Our Case Number: ABP-316272-23

Re: Bus Connects Templeogue/Rathfarnham to City Centre Core Bus Corridor Scheme
Templeogue/Rathfarnham to City Centre

The Templeogue / Rathfarnham to City Centre Core Bus Corridor Scheme (the Proposed Scheme)

<p>Date 27/01/2023 Scale 1:500 @ A1 1:1000 @ A3</p>		<p>Drawn JT Checked CMG Approved DC</p>		<p>Project Code BCIDC Originator Code ARP QMS Code 268401-00</p>		<p>Drawing File Name BCIDC-ARP-TSM_GA-1012_XX_00-DR-CR-0025</p>		<p>Sheet Number 25 of 42 Status A Rev M01</p>

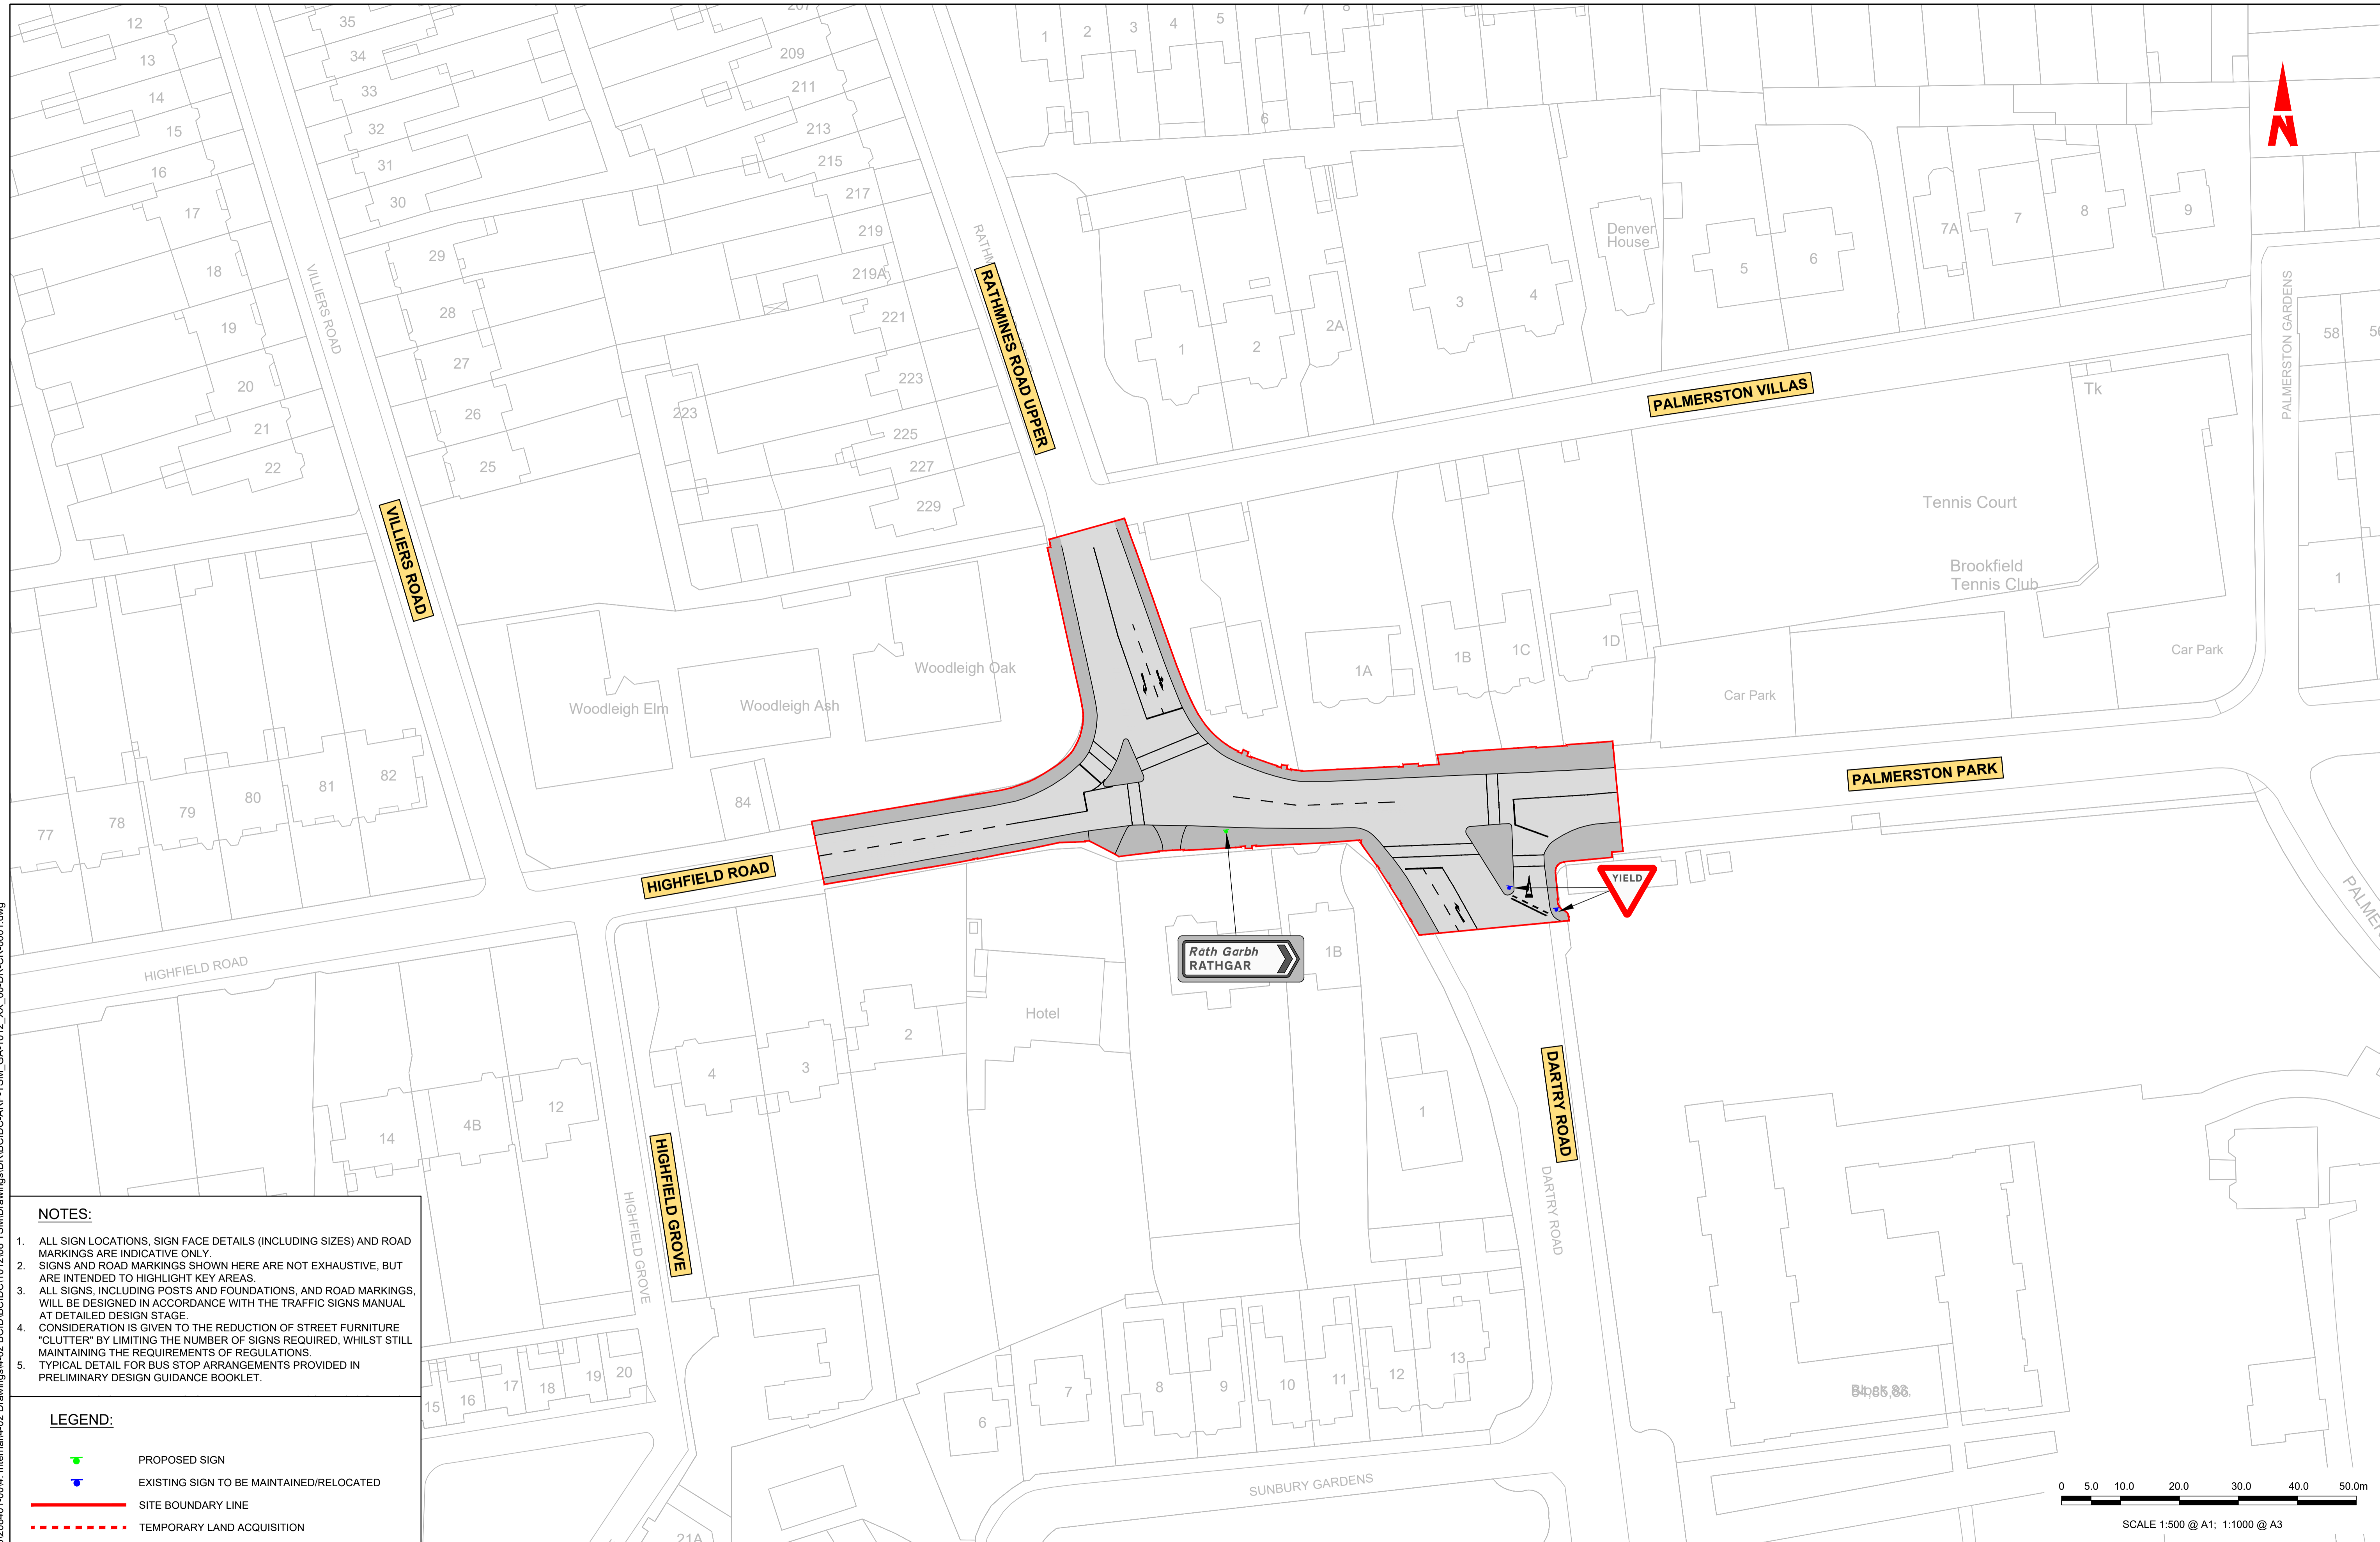
I also am objecting vehemently to a massive sign that has been noted to be installed outside my front door so when I look out my living room window, I will only see the back of a metal sign blocking any view of the neighbourhood. Ref Road Marking Page 29. BCIDC-ARP-TSM_GA-1012_XX_00-DR-CR-0026
